**EL PASO COUNTY PLANNING AND  
 COMMUNITY DEVELOPMENT  
 DEPARTMENT**

**STORMWATER MANAGEMENT PLAN CHECKLIST**

PCD Project Number: PPR-22-044

S9088-A-01-018
 PCD File No. PPR2244

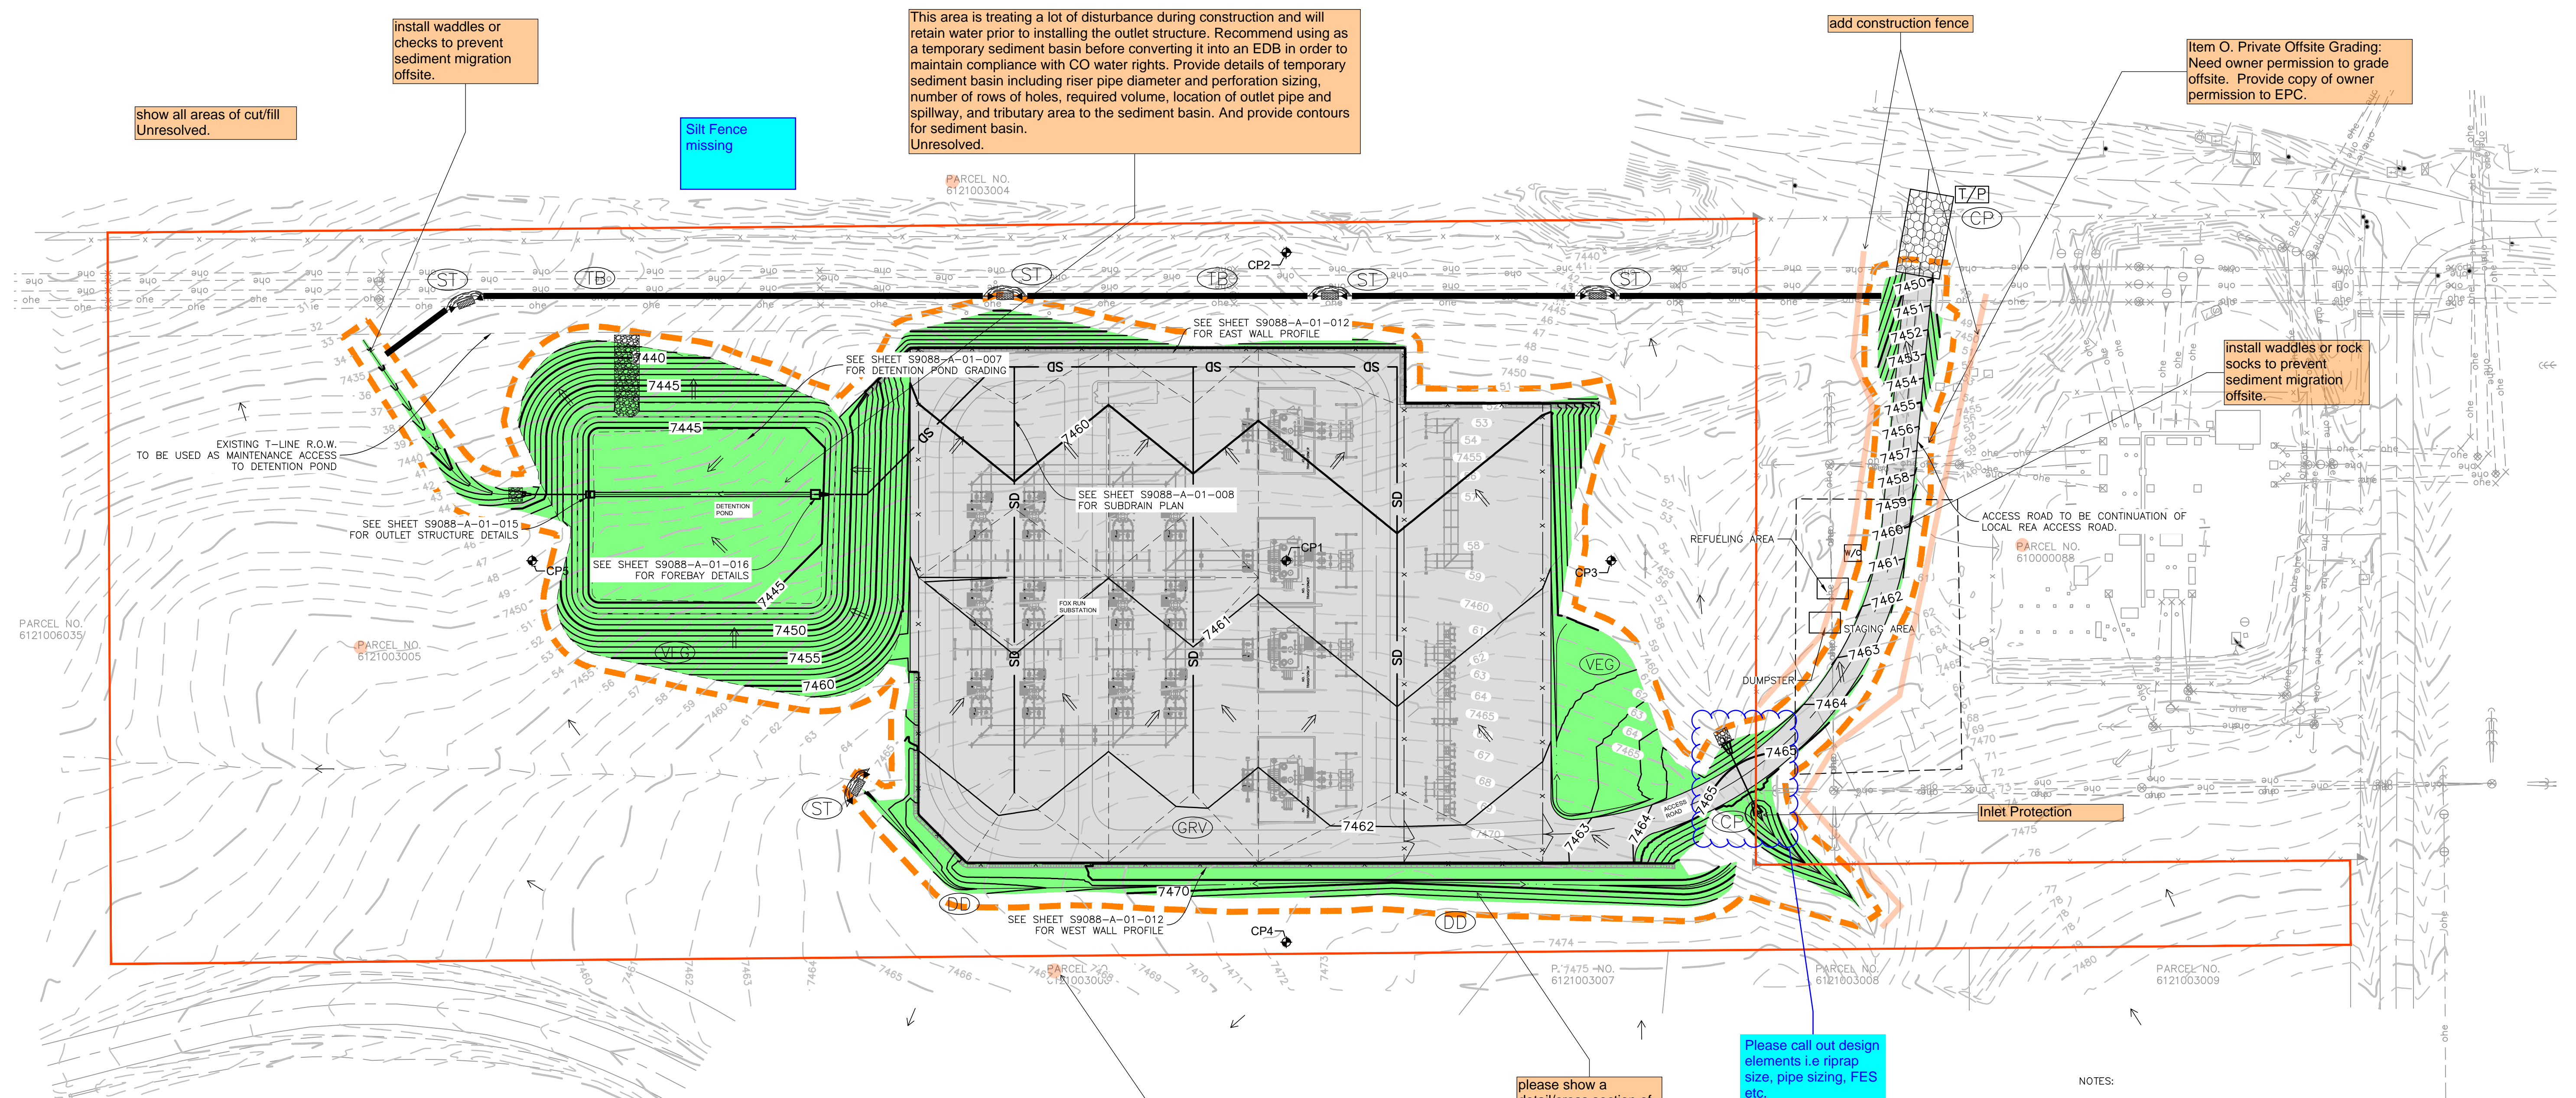
Applicant	PCD
17g	location of all structural control measures	X	X
17h	location of all non-structural control measures	X	X
17i	springs, streams, wetlands and other surface waters, including areas that require maintenance of pre-existing vegetation within 50 feet of a receiving water	X	✓
18	Narrative description of all structural control measures to be used. Modifications to EPC standard control measures must meet or exceed County-approved details.	X	✓
19	Description of all non-structural control measures to be used including seeding, mulching, protection of existing vegetation, site watering, sod placement, etc.	X	✓
20	Technical drawing details for all control measure installation and maintenance; custom or other jurisdiction's details used must meet or exceed EPC standards <b>see GEC</b>	X	X
21	Procedure describing how the SWMP is to be revised	X	✓
22	Description of Final Stabilization and Long-term Stormwater Quality (describe nonstructural and structural measures to control SW pollutants after construction operations have been completed, including detention, water quality control measure etc.) <b>Missing details on GEC plan</b>	X	X

b	Erosion and Stormwater Quality Control Permit (ESQCP) (signed)		X
<b>3. Applicant Comments:</b>			
a	<b>Update GEC plan which is used as Appendix A for this report.</b>		
b			
c			
<b>4. Checklist Review Certifications:</b>
